Project Name: TOWN OF ATRISCO GRANT - TBKA LOPEZ WEST SUBD

DEVELOPMENT REVIEW BOARD – SPEED MEMO

DRB CASE NO: 1008926

**CITY OF ALBUQUERQUE
PLANNING DEPARTMENT
June 6, 2012
DRB Comments**

**PLAT OF  
LOTS 1-6  
LOPEZ WEST  
PROJECTED SECTION 26, T10N, R2E N.M.P.M.  
TOWN OF ATRISCO GRANT  
CITY OF ALBUQUERQUE  
BERNALILLO COUNTY, NEW MEXICO  
JULY 2012  
SHEET 2 OF 2**

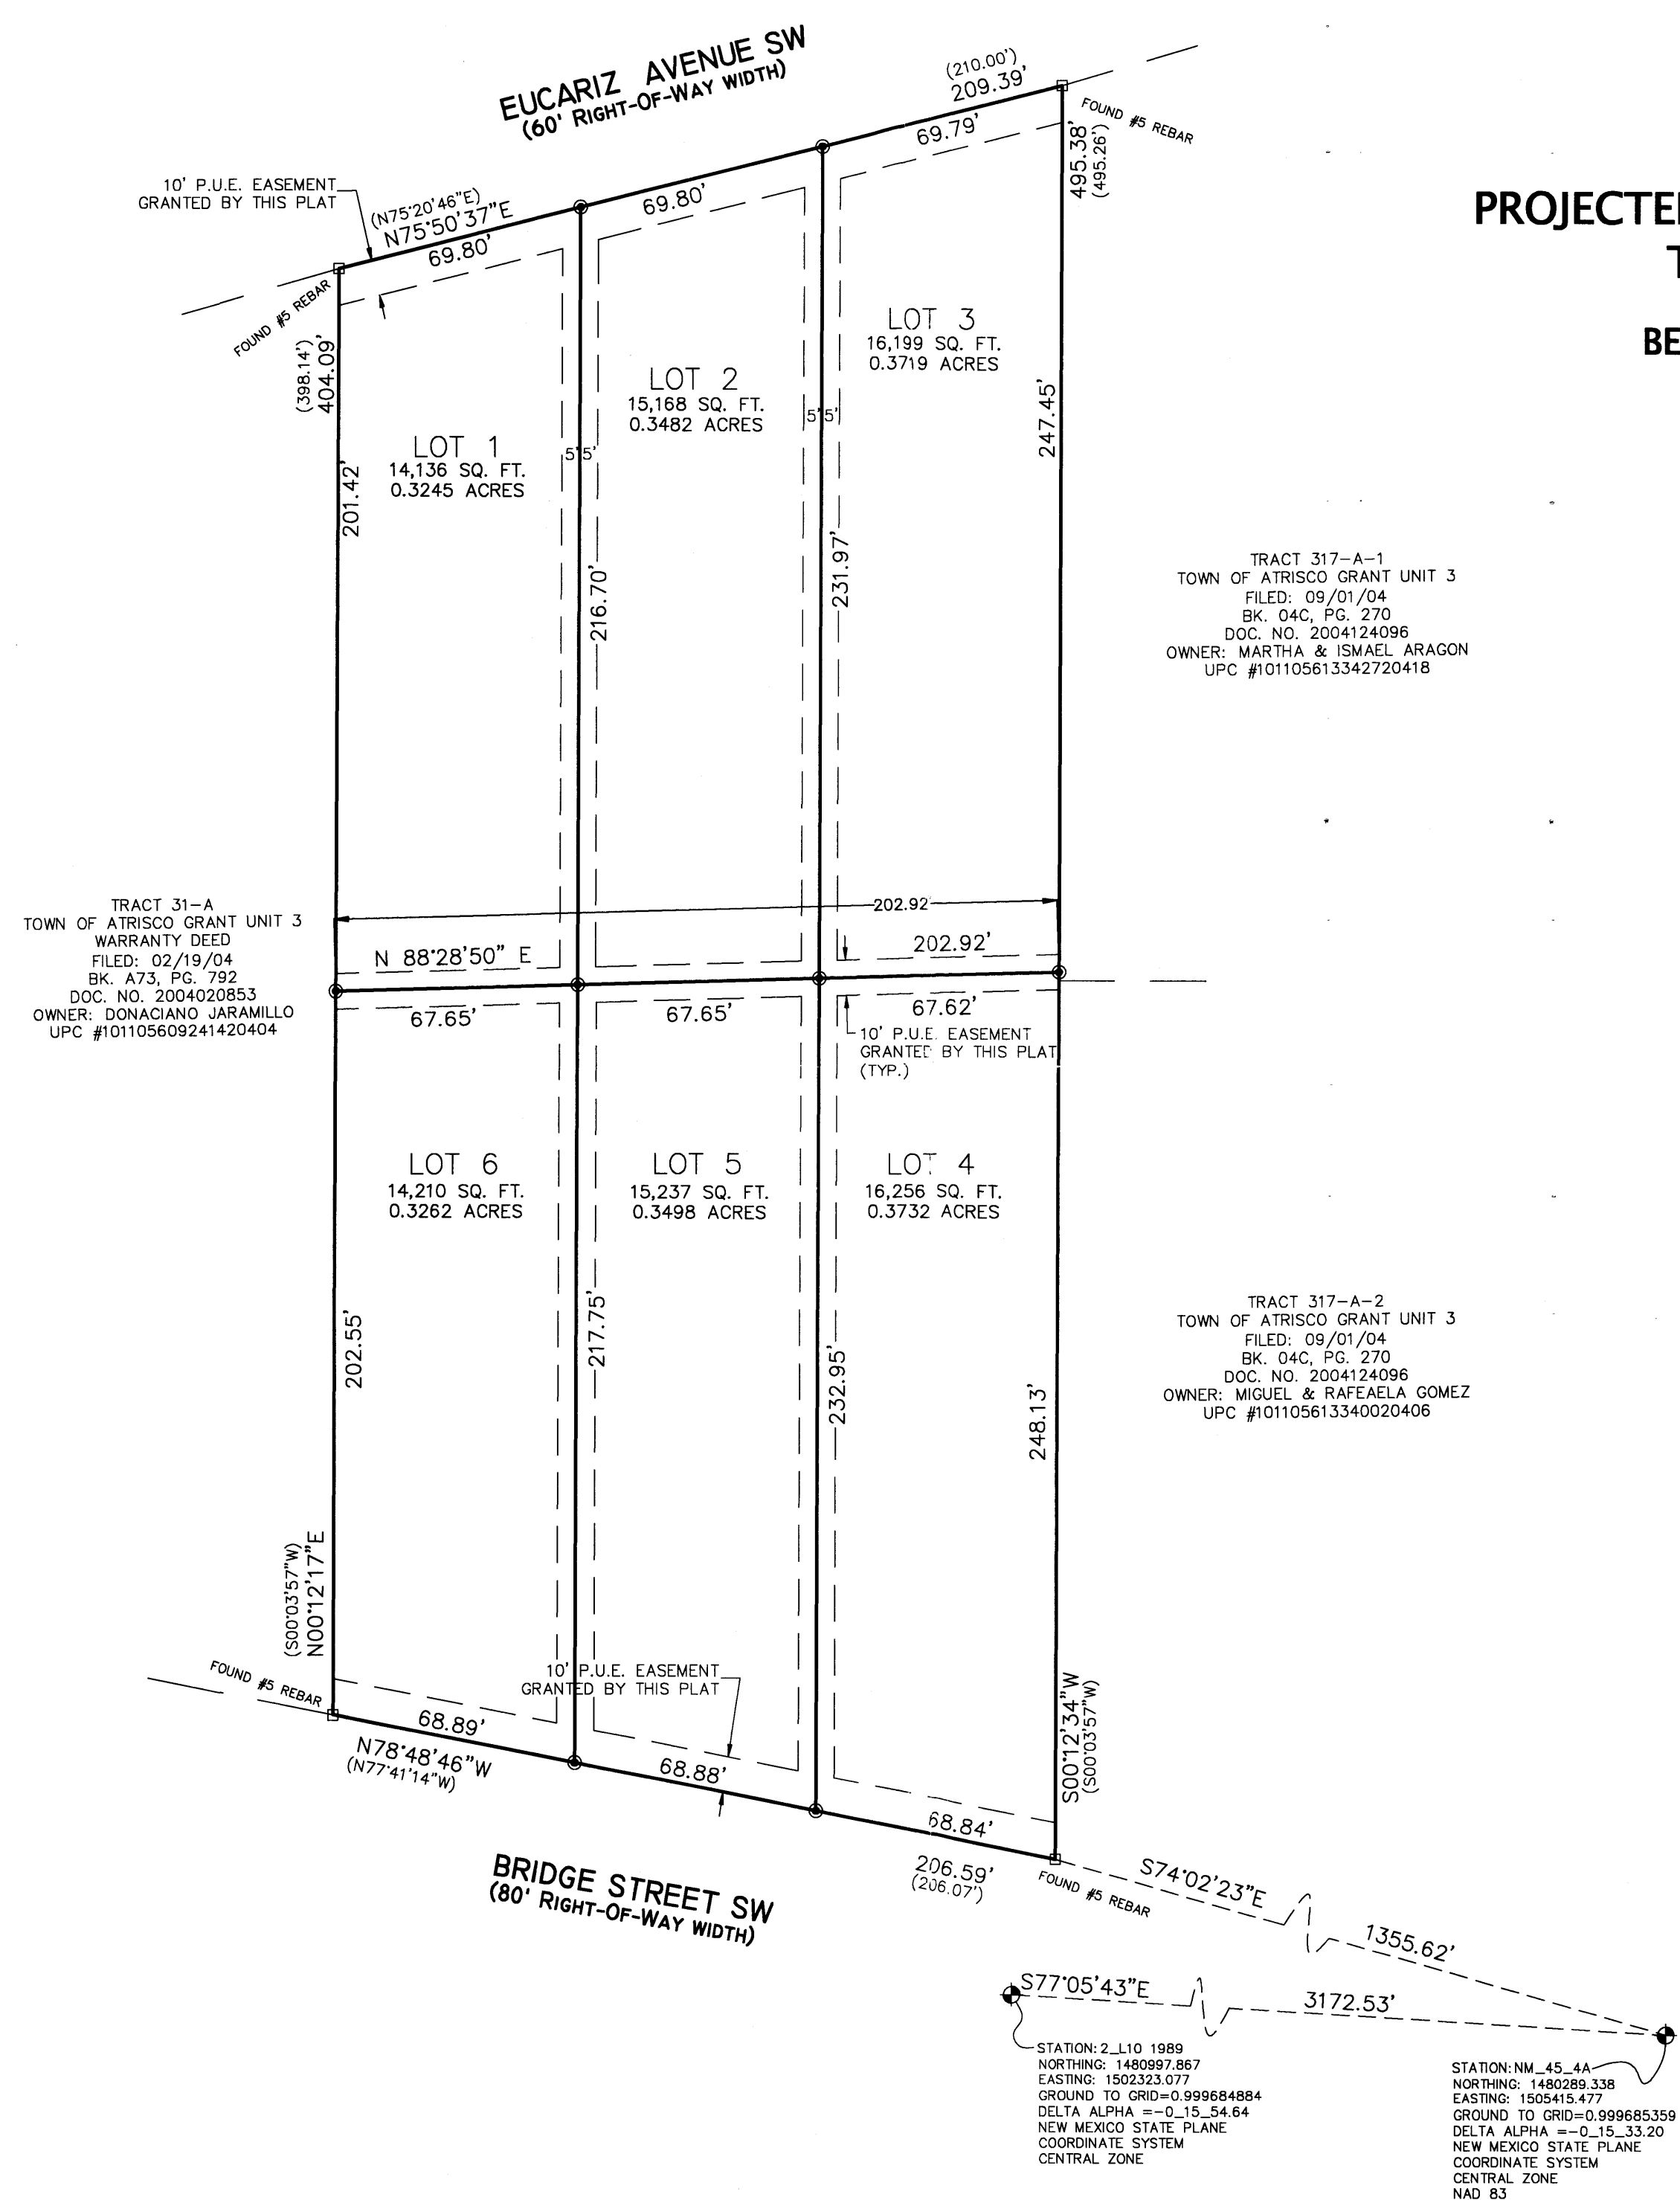
Adjacent platting on Sheet 2 of proposed plat needs to be corrected: Lot 315-A on the west side, and show correct right of way for Bridge on the east side for Lot 317-A-2.
